**Consultation Response from KC,  
Highways Development Management****2025/90453 46, Stile Common Road, Primrose Hill, Huddersfield, HD4 6DE****Erection of 2 dwellings for student accommodation and emergency housing****Date Responded: 15-4-2025.****Responding Officer: Mark Berry.****Responding Ref: 6-9SE-8.**

This application seeks approval to the erection of two 5 bedroomed dwellings for student accommodation and emergency housing at 46, Stile Common Road, Primrose Hill, Huddersfield.

10 Site Plan
1 : 200

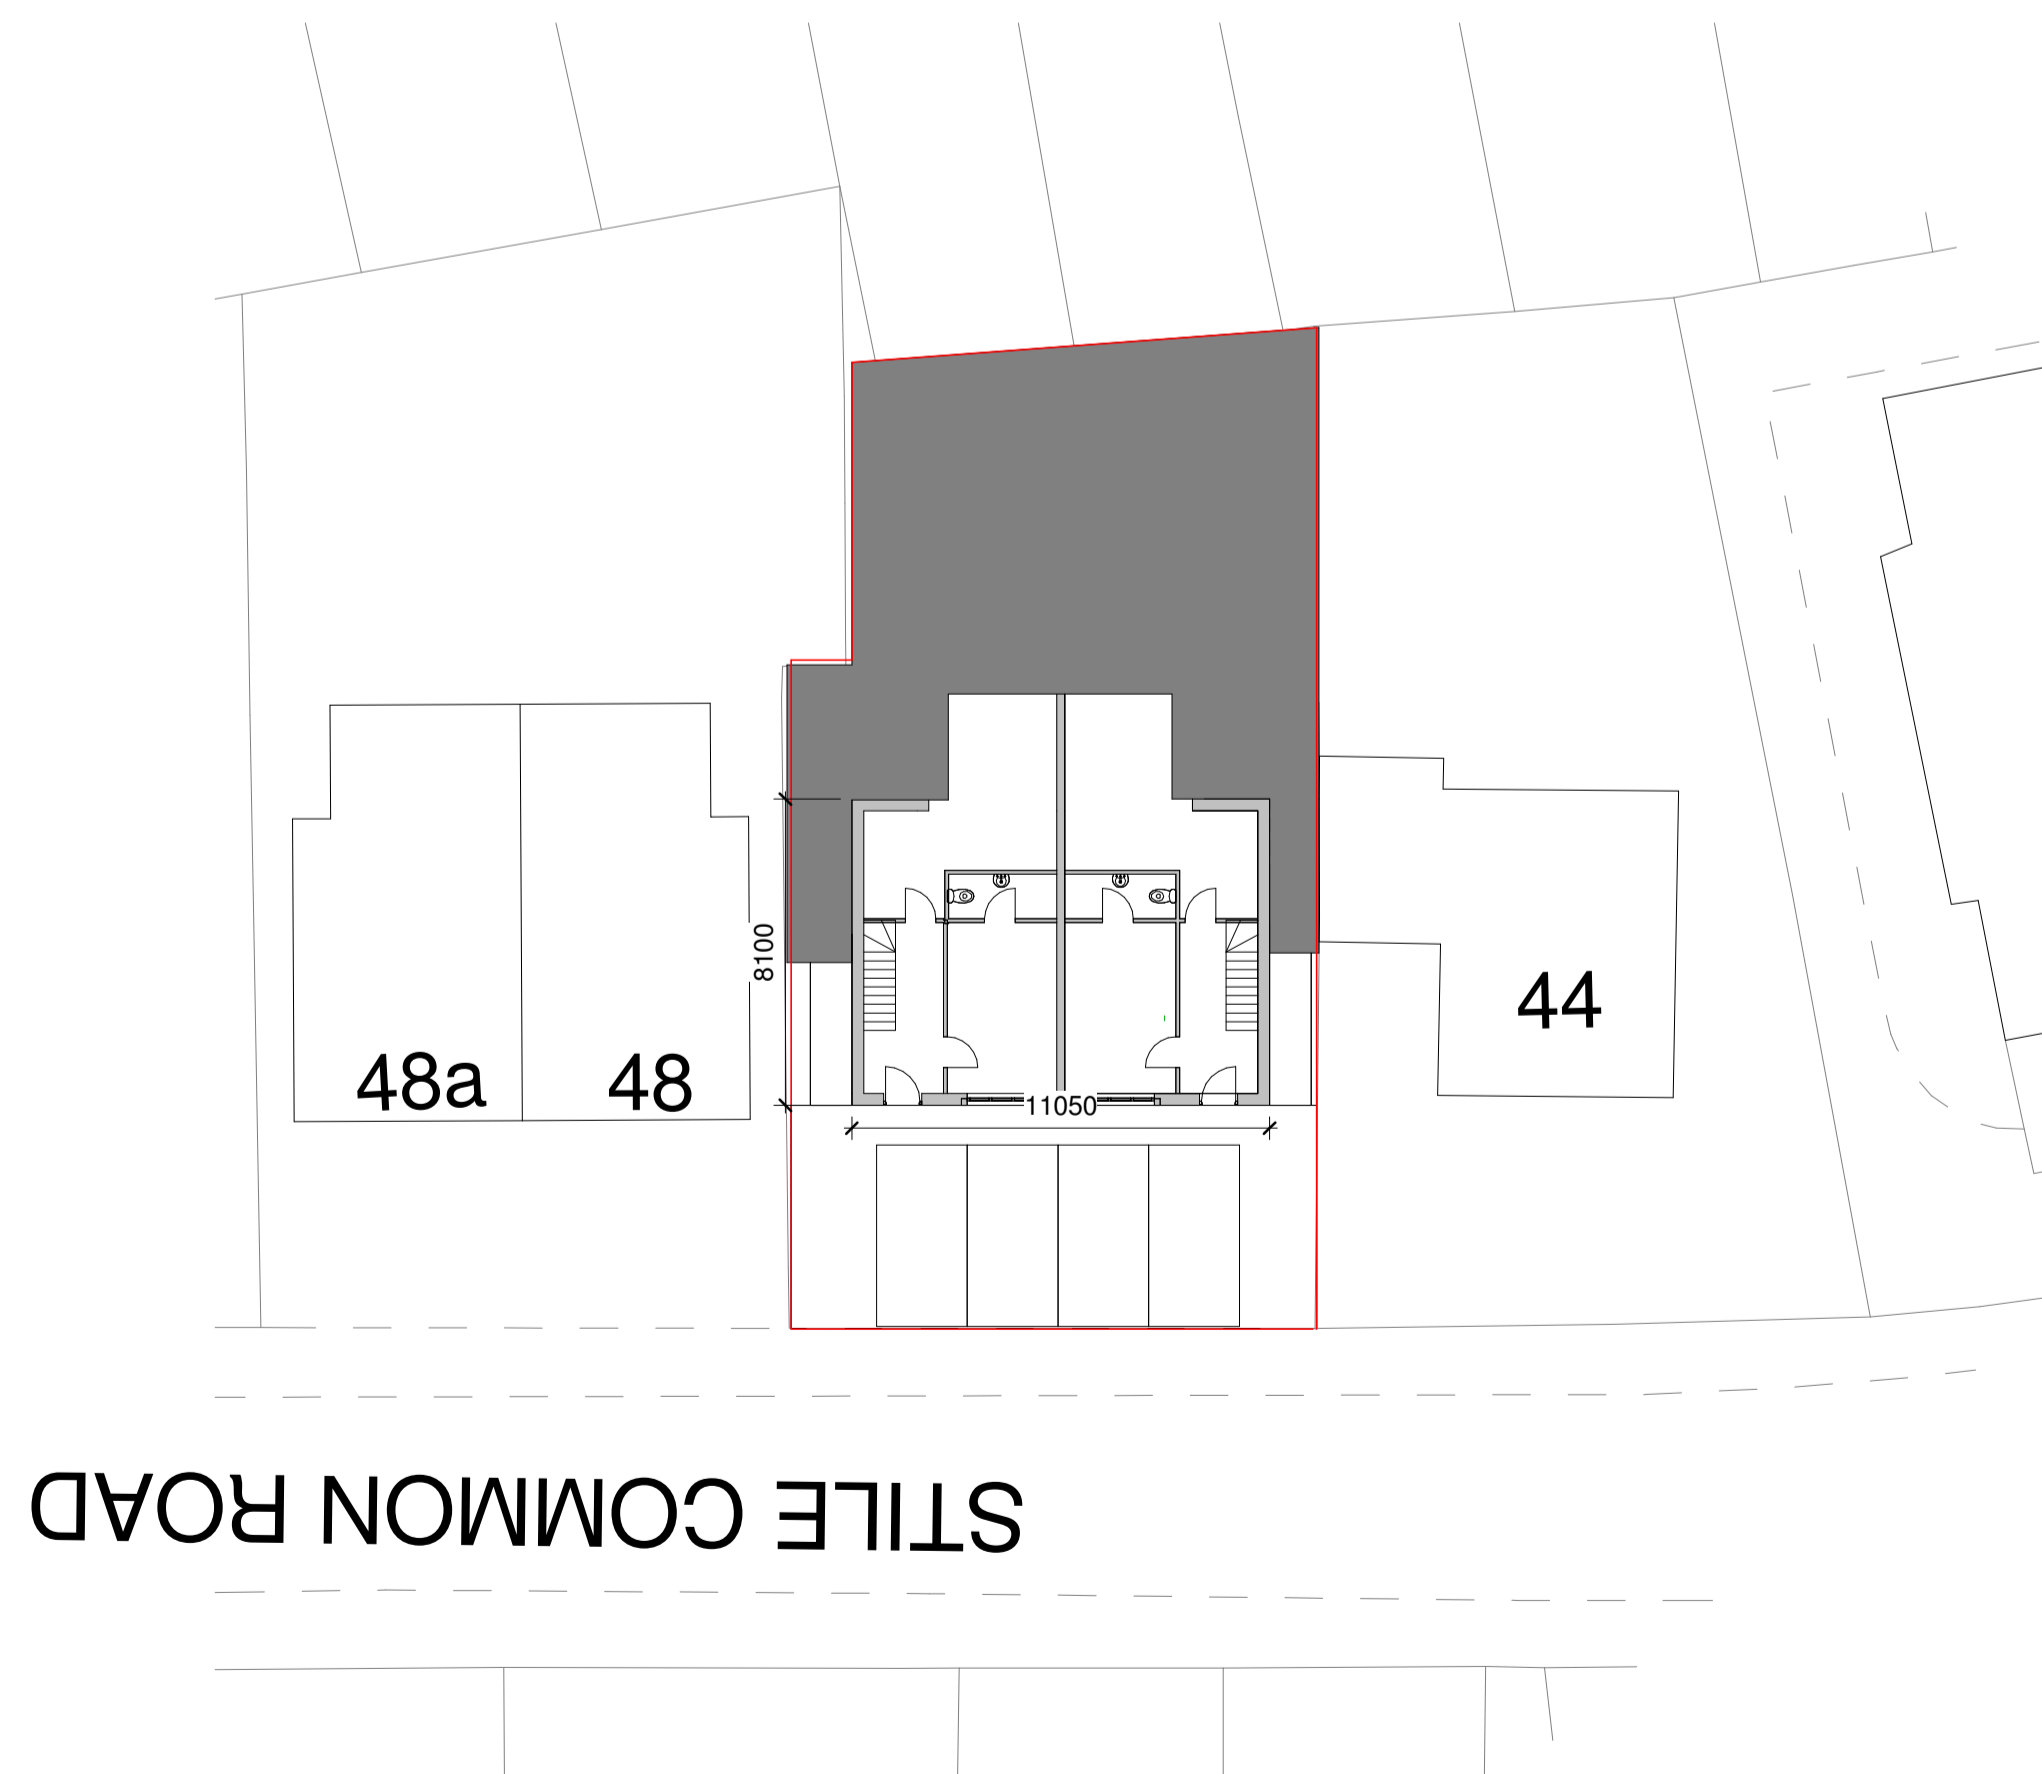
This application however now seeks to include emergency housing, but no information is provided to justify why the proposed off street parking provision will remain sufficient or the anticipated traffic generation compared to student use.

No details of the proposed bin collection points are provided.
